Submission on a Strategic Infrastructure Planning Application

Re: Proposed Tirawley Wind Farm Strategic Infrastructure Development

Applicant: Constant Energy Limited

Case reference: PAX16.324258

Plate 12.5: Excerpt from Map 10.1 showing landscape policy areas in relation to the Proposed Development in the current Mayo CDP (2022-2028)

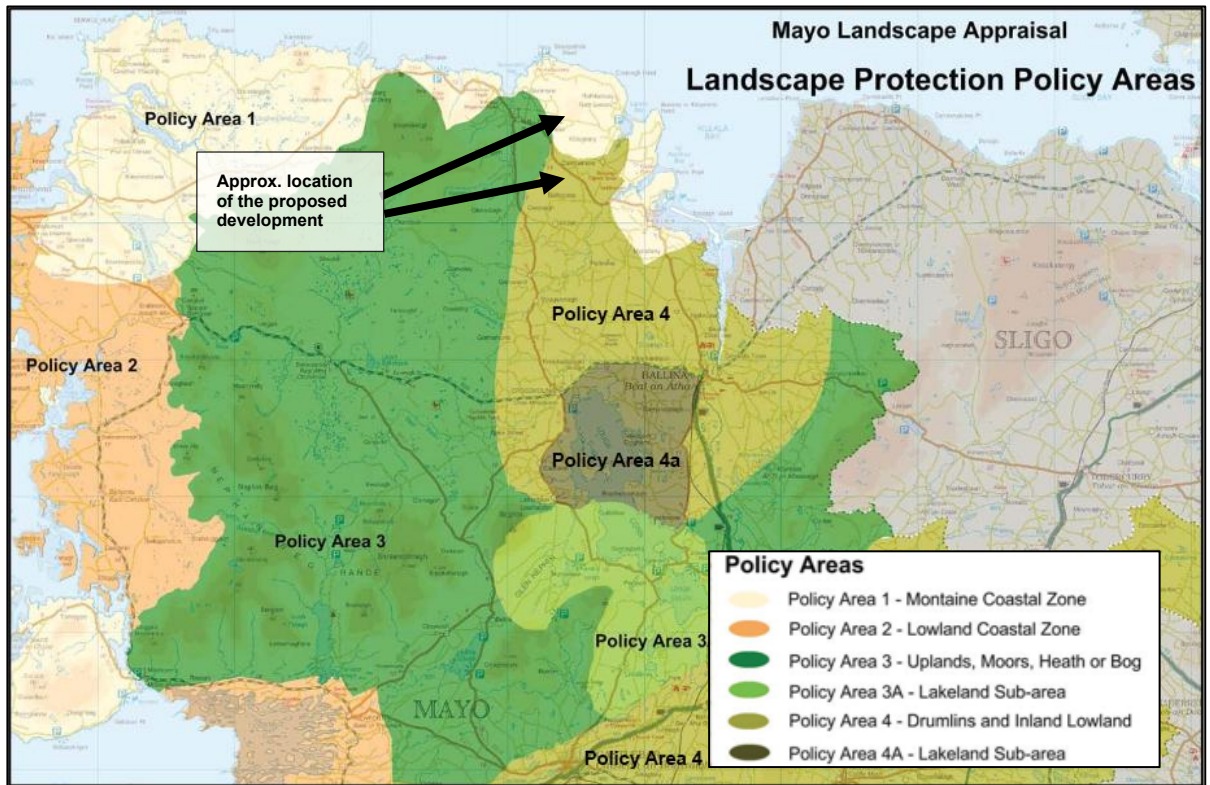
The reduction was triggered, according to the developer, after a 2023 pre-planning meeting with the local authority raised these concerns. The relevant entry in the minutes of that pre planning was “The larger turbines are located in Landscape Policy Area 1 where it is unlikely that the visual impact of windfarms can be ameliorated.”

Critically, claims in the EIA that landscape impacts are mitigable by planting, layout adjustments, or localized screening ignore the open topography and wide visibility of turbines, which makes mitigation ineffective from most key viewpoints. The larger turbines are located in Landscape Policy Area 1 where it is unlikely that the visual impact of windfarms can be ameliorated.

Figure 12.1 ZTV (Zone of Theoretical Visibility) indicating the areas that have a potential view of the proposed turbines at Tirawley Wind Farm (135m Tip Height)

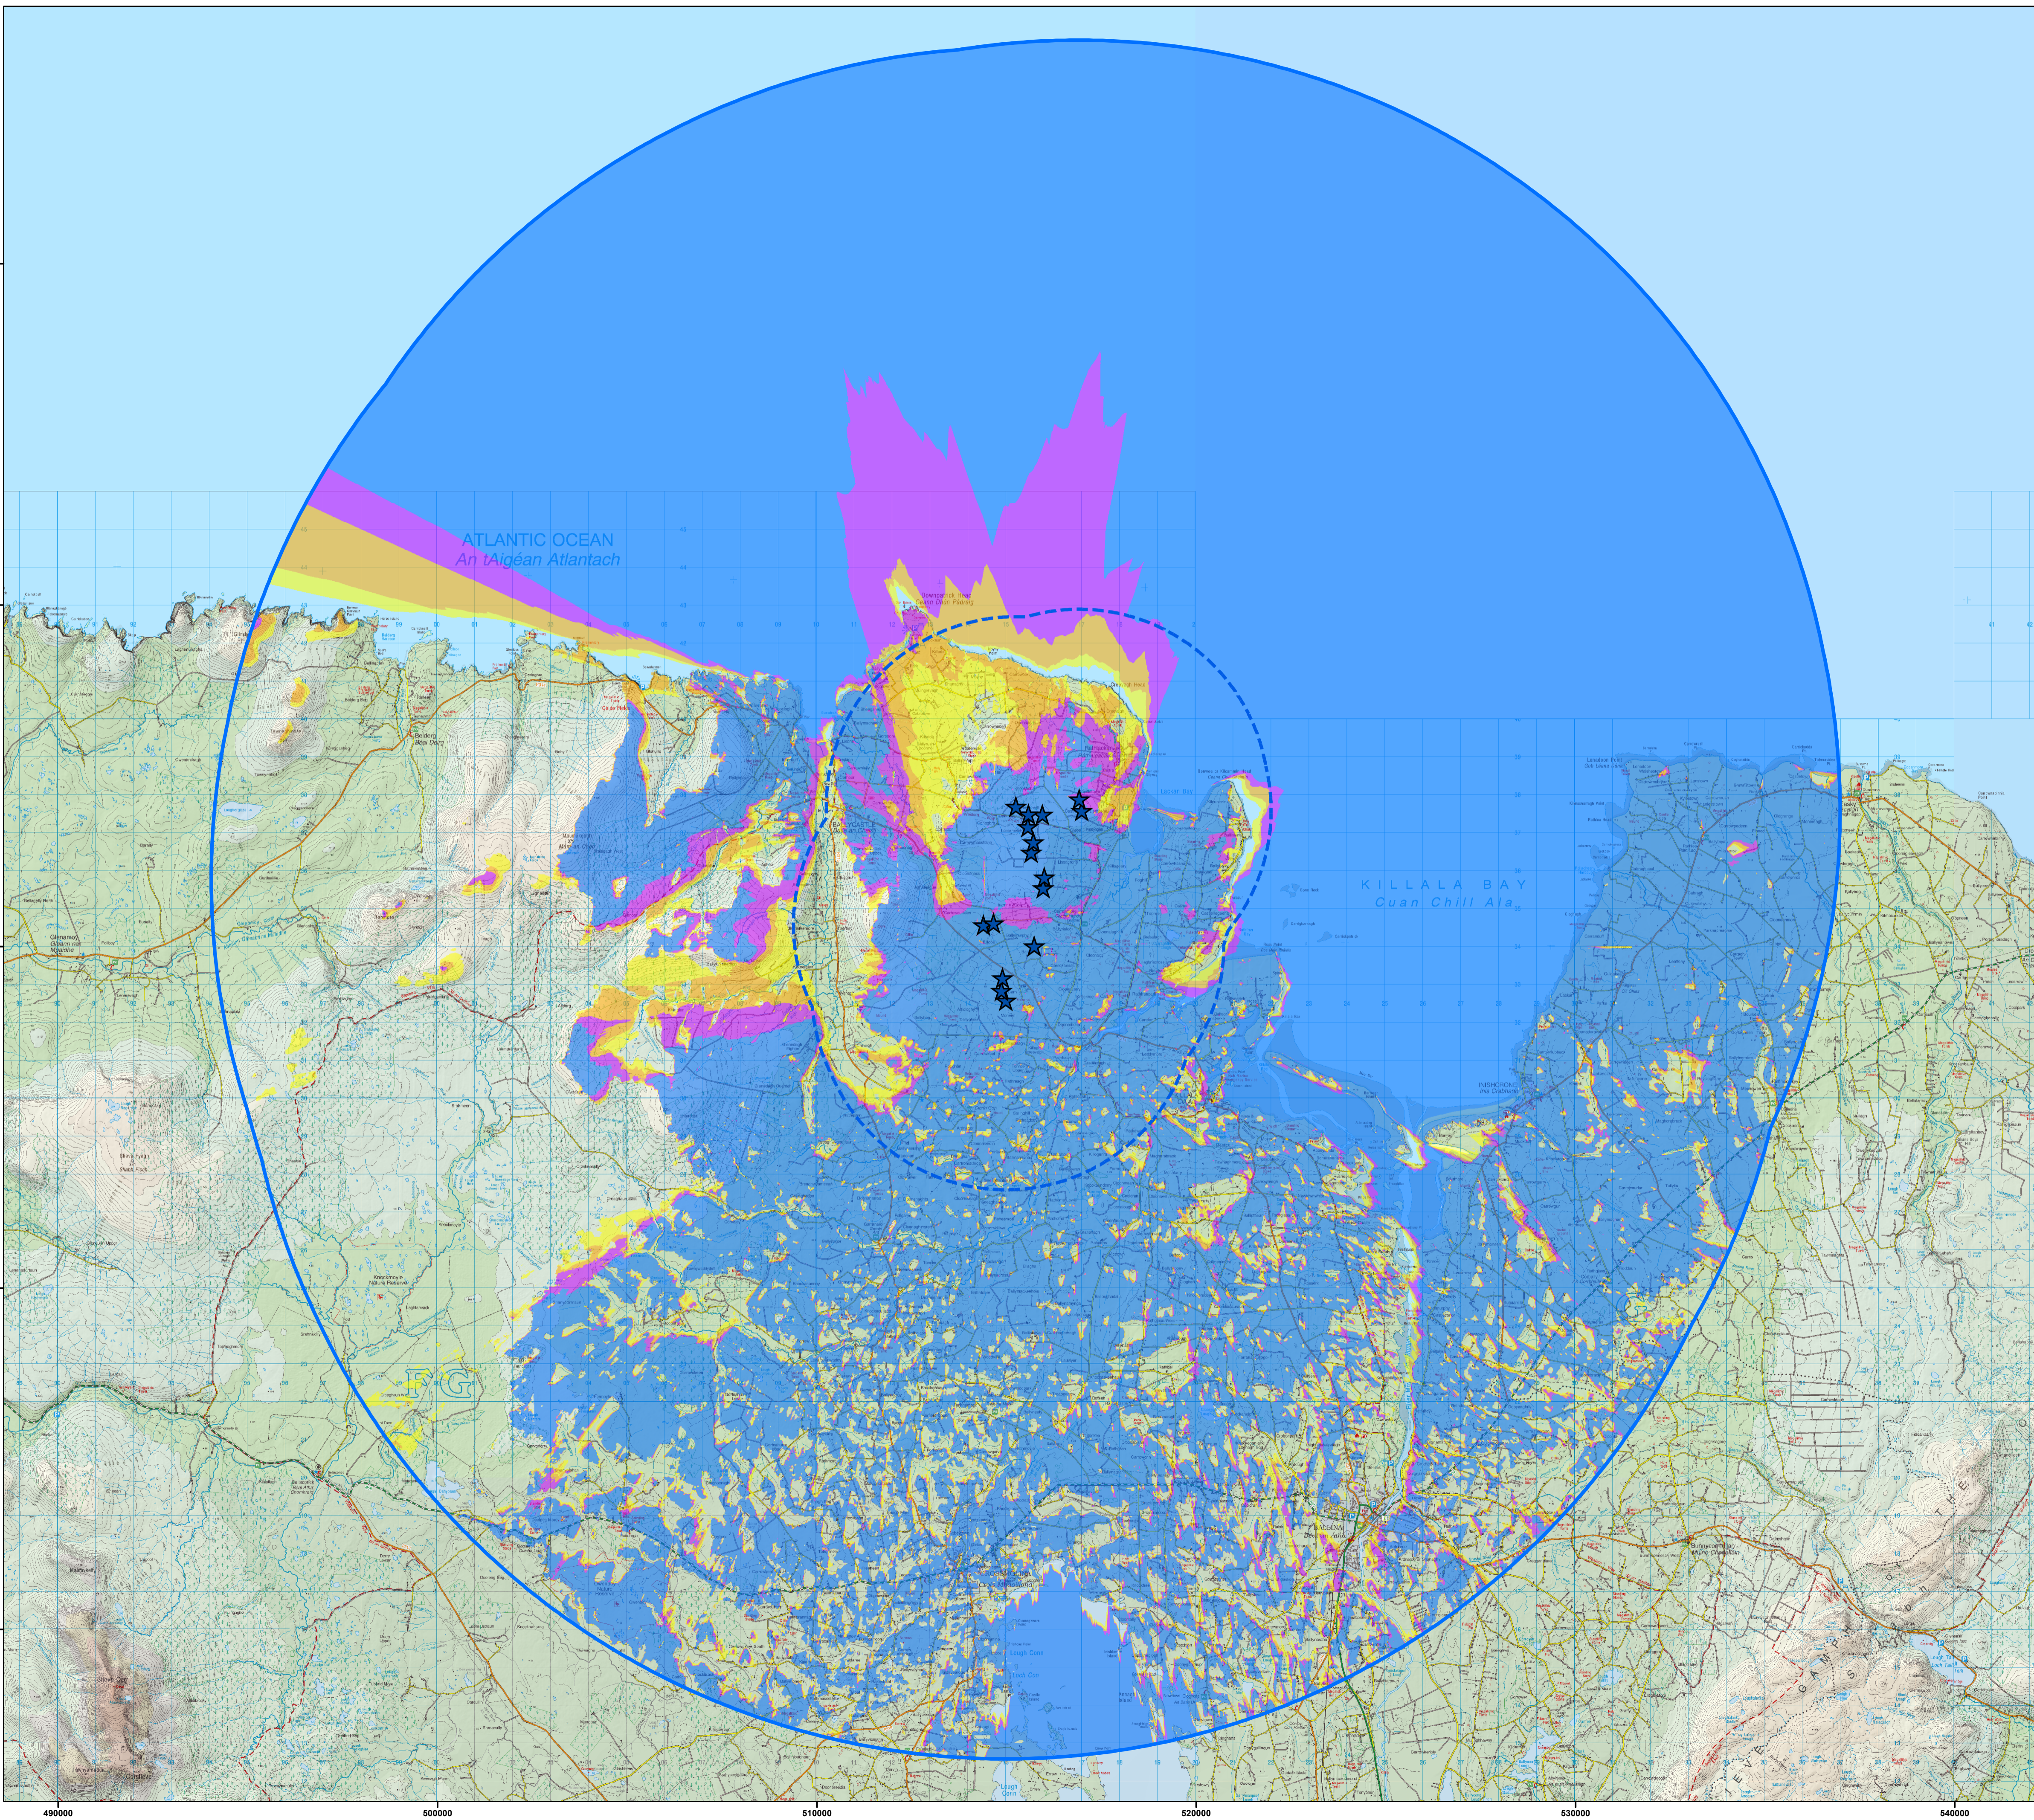
In some instances, the assessment underestimates the scale and permanence of visual intrusion by categorizing certain impacts as “moderate” or “not significant.”

Figure 12.3 ZTV indicating the cumulative theoretical visibility of the proposed Tirawley Wind Farm in combination with all other wind farms in the study area

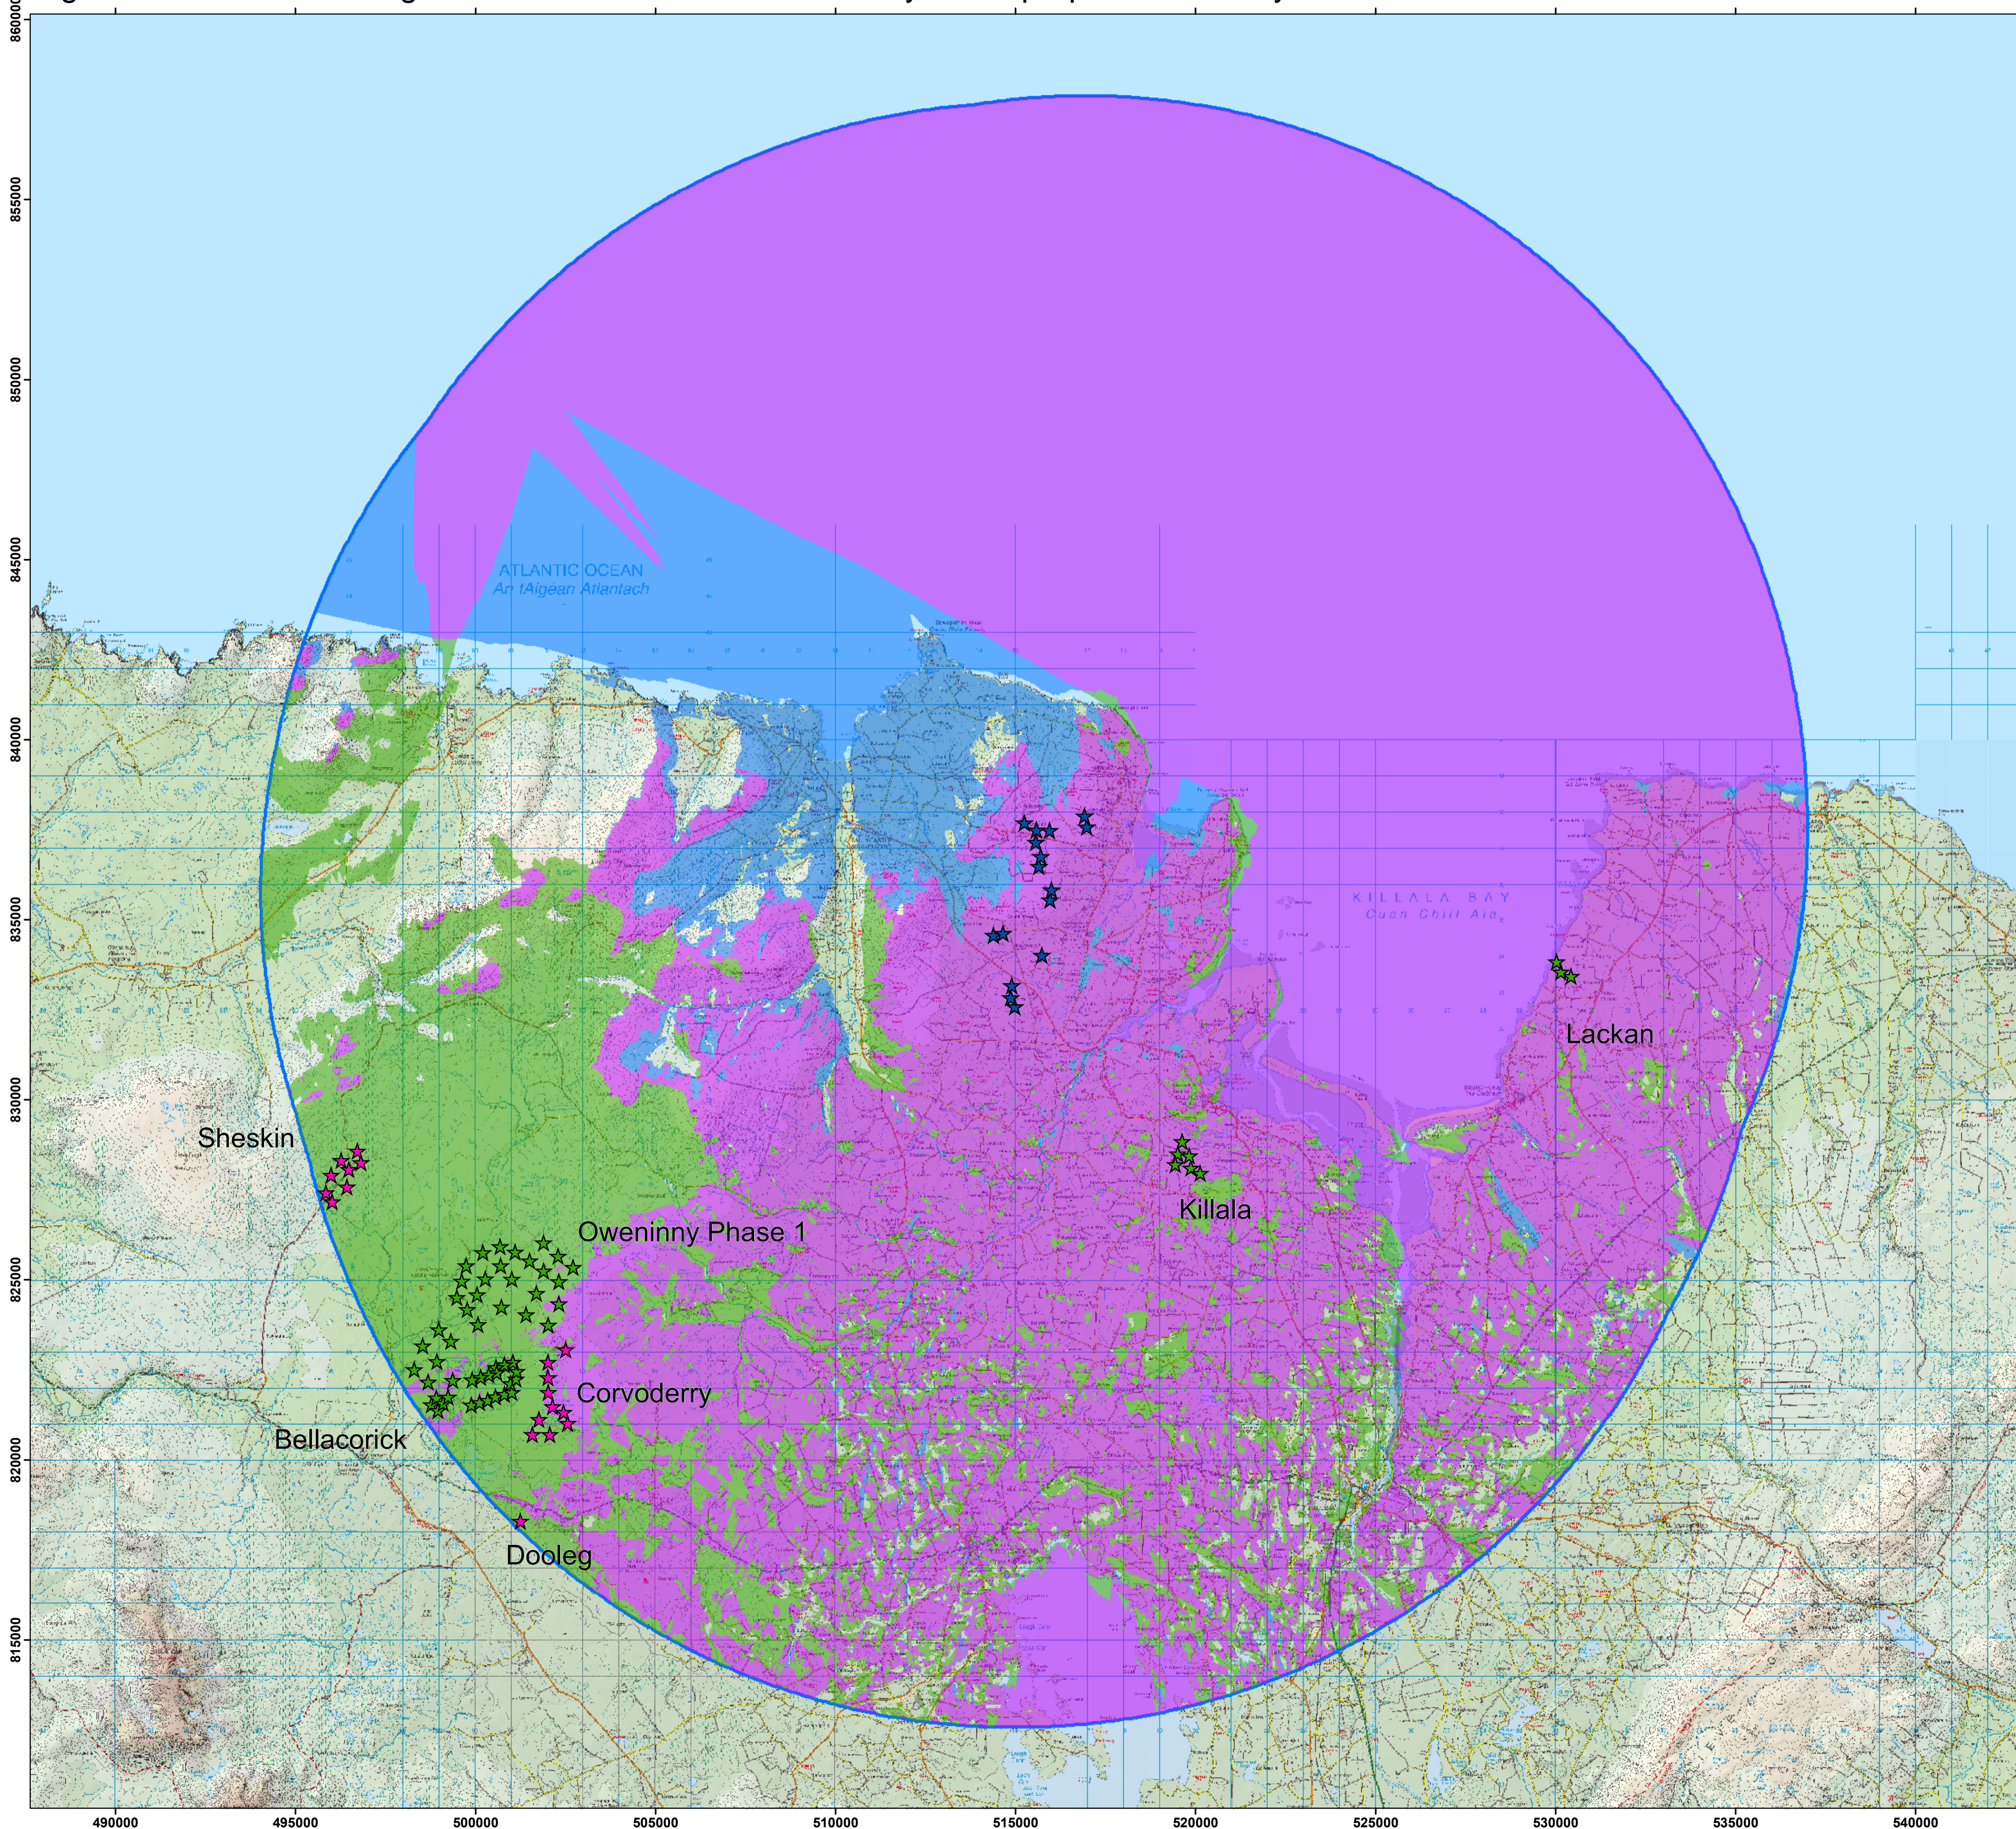
The EIS further exaggerates the temporary nature of construction impacts and underrepresents the cumulative visual effects by assessing turbines individually rather than as a group, despite evidence that clustered projects have compounding adverse effects on visitor perceptions and tourism outcomes. Local residents and tourism stakeholders have consistently argued that such damage cannot be reversed.
